Application by Augean South Limited for an Order granting Development Consent for the East Northants Resource Management Facility Western Extension

The Examining Authority's Schedule of Changes to the Applicant's draft Development Consent Order published on Wednesday 29 June 2022.

The following table sets out the Examining Authority's (ExA's) Schedule of Changes to the draft Development Consent Order (dDCO) submitted by the Applicant at Deadline 6 on 22 June 2022 [REP6-014].

Figure ESA5.1 Scale: 1:2,500@A2

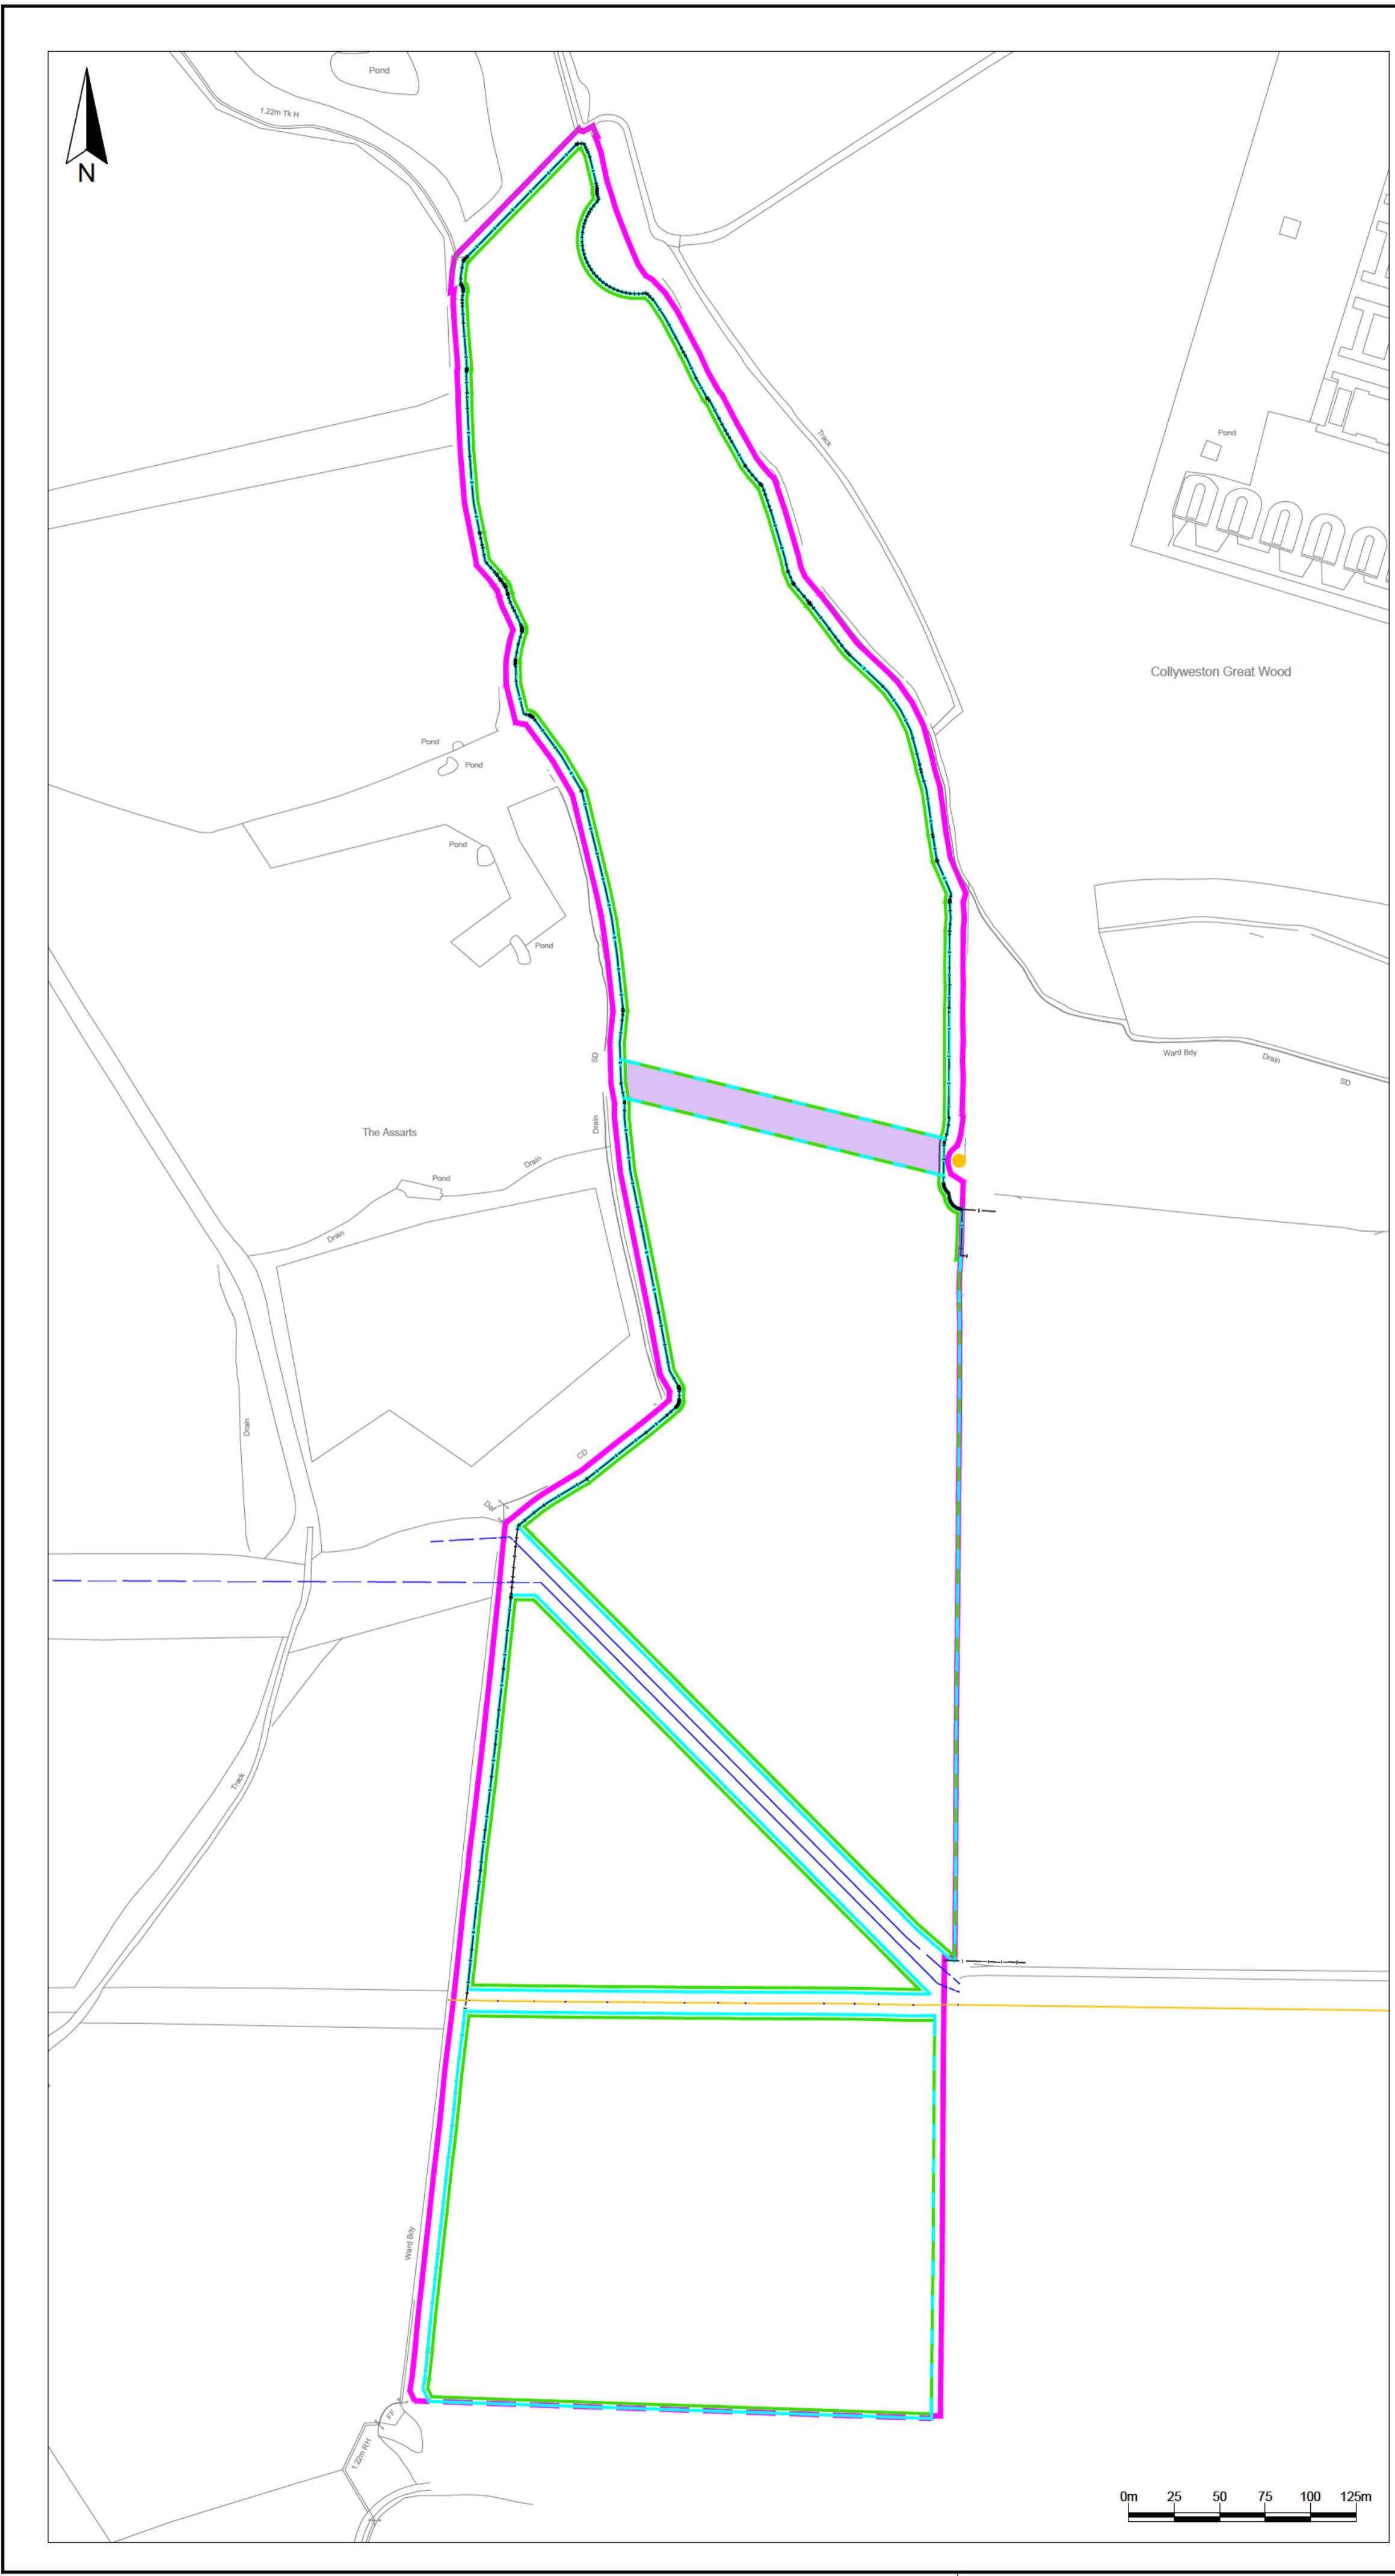
No	Text as set out in [REP6-013]	ExA's suggested change	ExA's reasoning
1	ARTICLE 2 Interpretation N/A	Add definition of 'water pipe standoff'	To assist in the interpretation of Requirement 19 and accord with the Applicant's Schedule of Changes to the dDCO V3 [REP6-006].
2	SCHEDULE 6 Protective Provisions PART 1 FOR THE PROTECTION OF ELECTRICITY, GAS AND WATER UNDERTAKERS 1. For the protection of the utility undertakers referred to in this Part of this Schedule the following provisions have effect, unless otherwise agreed in writing	Omit all of Part 1 and re-number the remainder of Schedule 6: subject to the relevant statutory undertakers satisfying themselves that the bespoke provisions (currently Parts 2 (Western Power Distribution) and 3 (National Grid) of the dDCO and emerging text set out in [REP6-016] (Anglian Water) cover all necessary protective provisions.	Part 1 largely replicates the bespoke provisions to be included for each statutory undertaker.
